Development Control
Ribble Valley Borough Council

App no: 24.0613

Address: Inglemead Waddington Road Clitheroe

Proposal: Proposed demolition of existing single garage and construction of new single-storey two-bedroom dwelling.(Self build)

project	drawing number		
inglemead	24.25		
name			
proposed site plan			
scale	date	status	revision
1 to 125 @ A1	july 24	planning	A

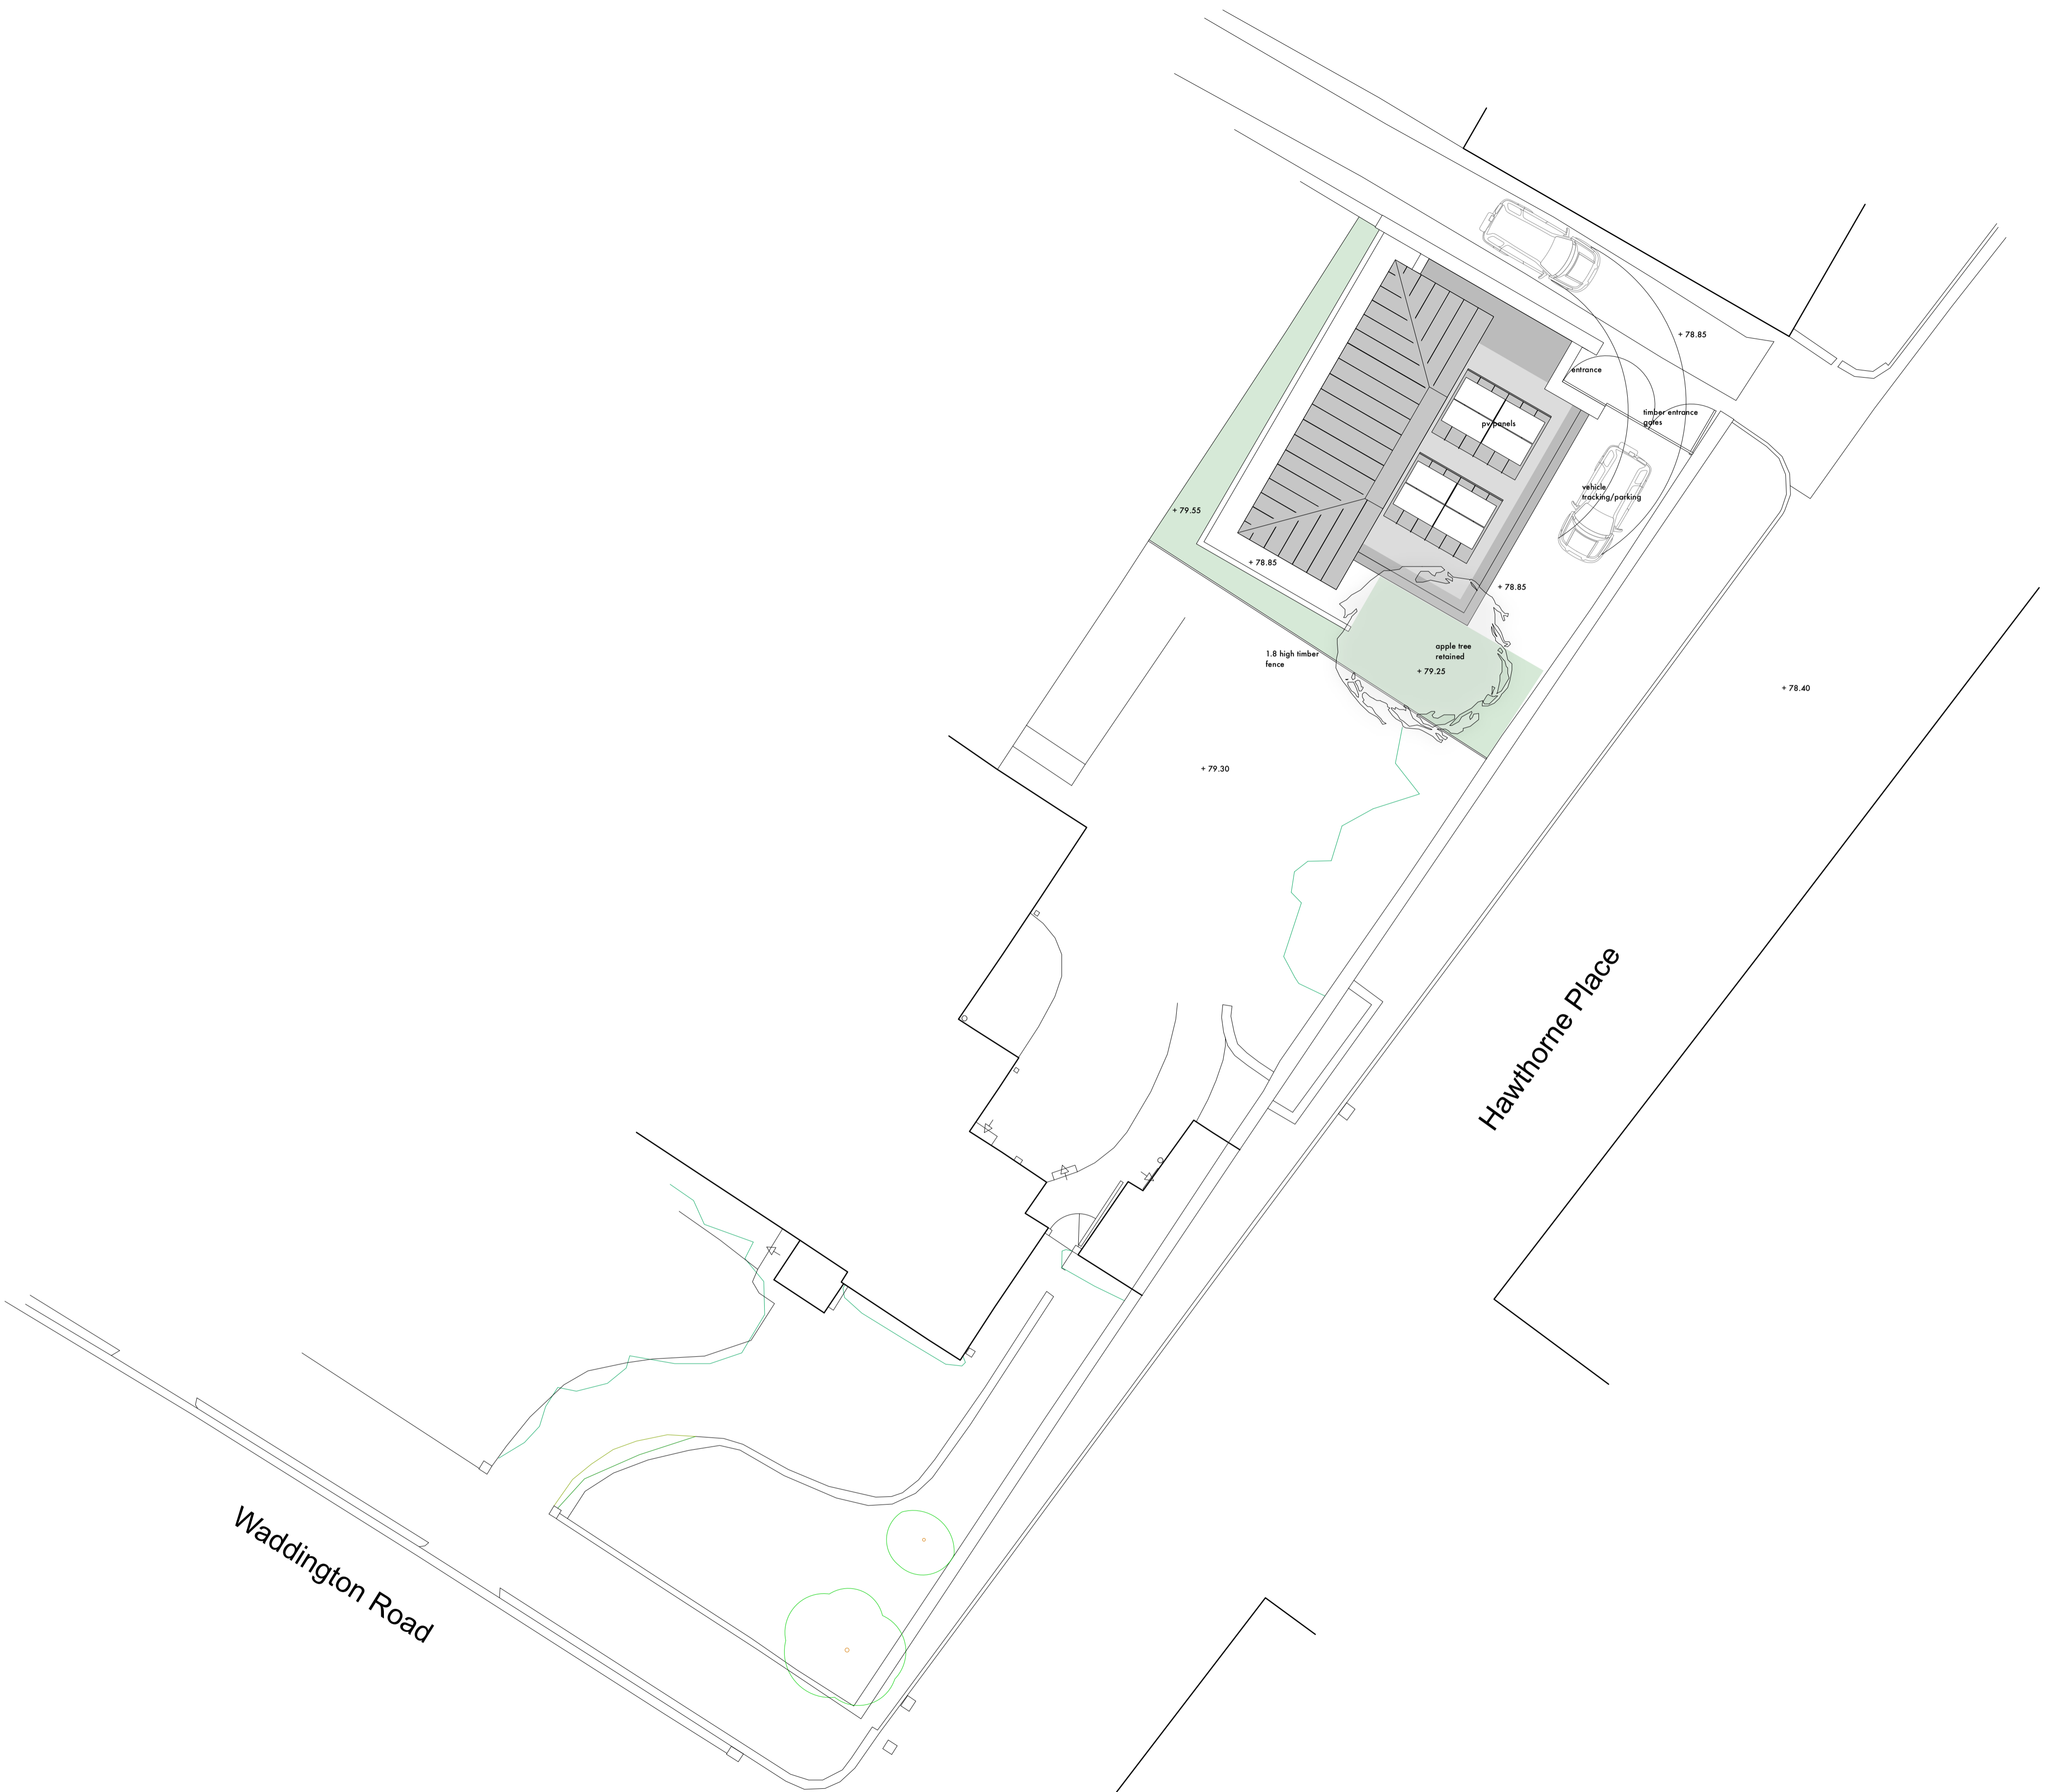
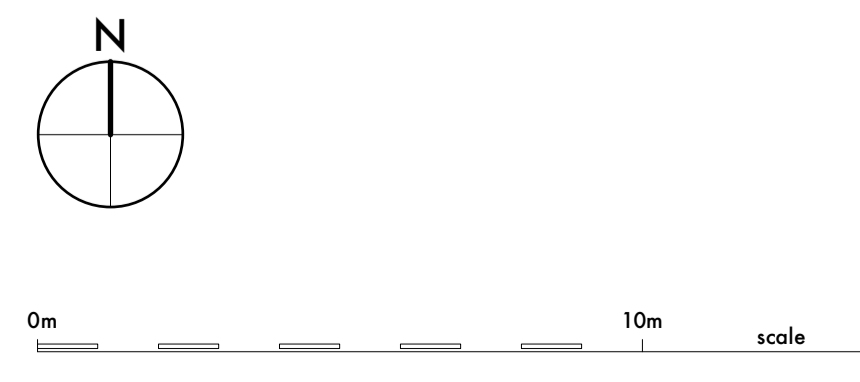
The proposed access uses an existing garage access. The proposed dwelling will result in an intensification of use. The access is constrained and has poor visibility due to the high boundary wall adjacent to the highway and back street. The drivers

will be required to undertake multiple reverse manoeuvres to and from Waddington Road which is not supported by the Highway Authority.

When visiting the site it was noted that the back street is used as a pedestrian route and refuse bins are stored there which both cause conflict with the constrained access position.

The current application proposes to provide a driveway measuring approximately 9.5m long by 3.75m wide which will provide a single off-road parking space (2 small spaces) accessed from the existing garage access on the back street.

The driveway must be paved in a porous bound material.

Secure and covered cycle parking is required to be provided.

Lancashire County Council acting as the Highway Authority would raise an objection regarding the proposed development and are of the opinion that the proposed development will have a significant impact on highway safety, capacity or amenity in the immediate vicinity of the site.
